From: Michael Flory
Sent: Monday, November 24, 2014 12:06 PM
To: Kaycee Hathaway
Cc: Lou Whitford
Subject: RE: BL-14-00023 Darling II: Notice to Agencies

[BL-14-00023 Darling II](#)

Revised Parcel 23

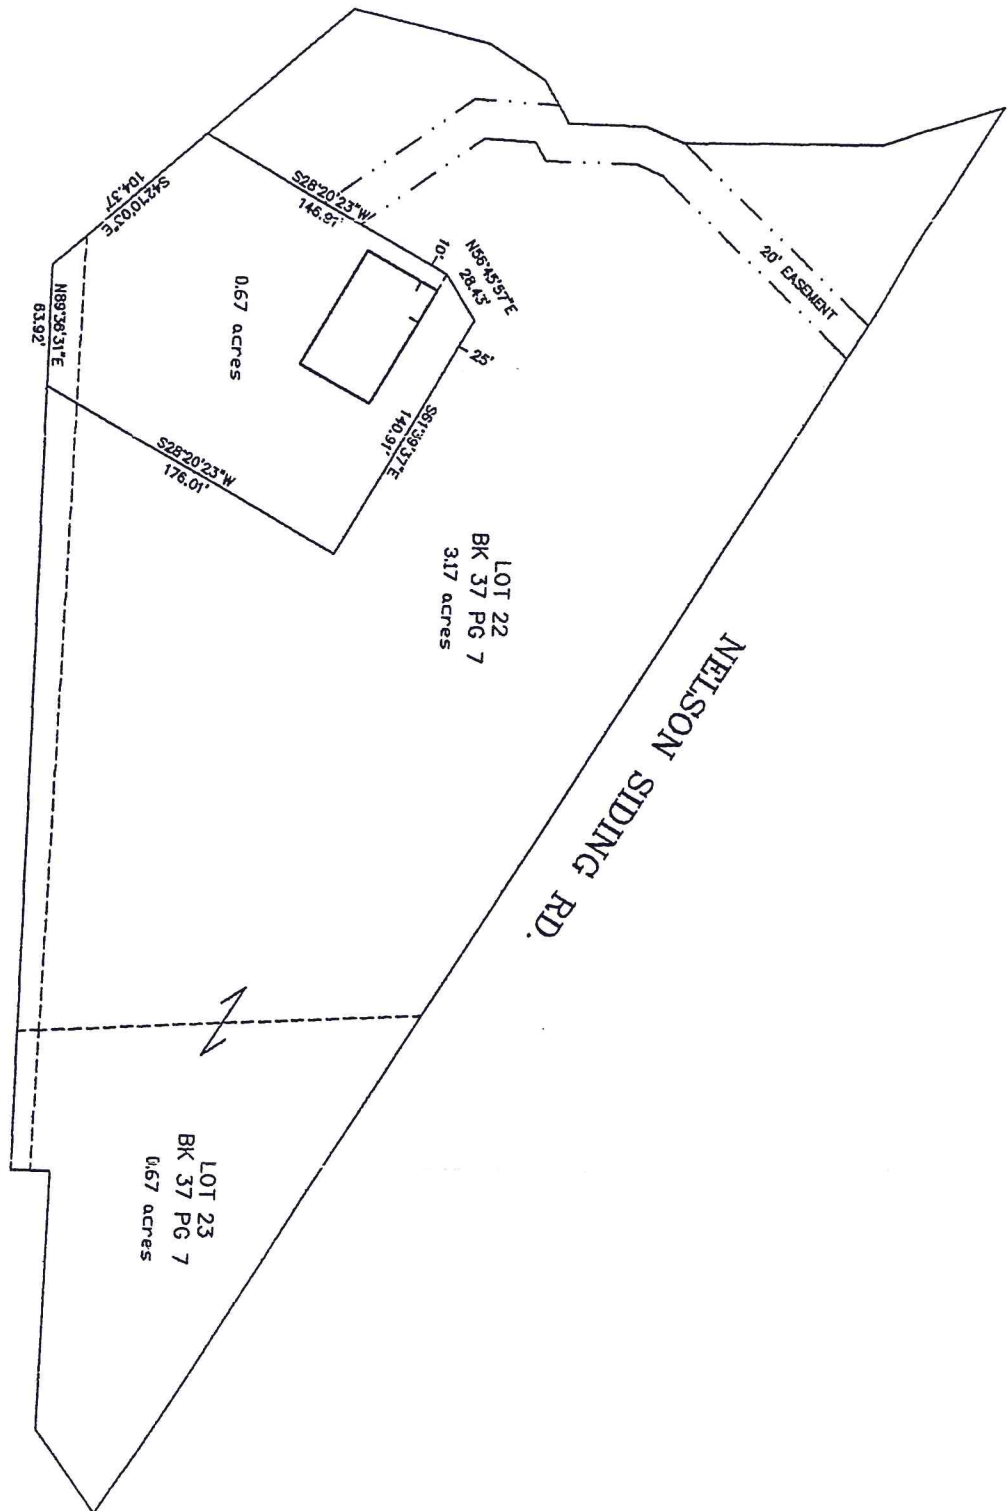
Setbacks to property lines shall be met per KCC or by variance.
Any encroachment to a property line closer than five (5) feet will require fire protection.
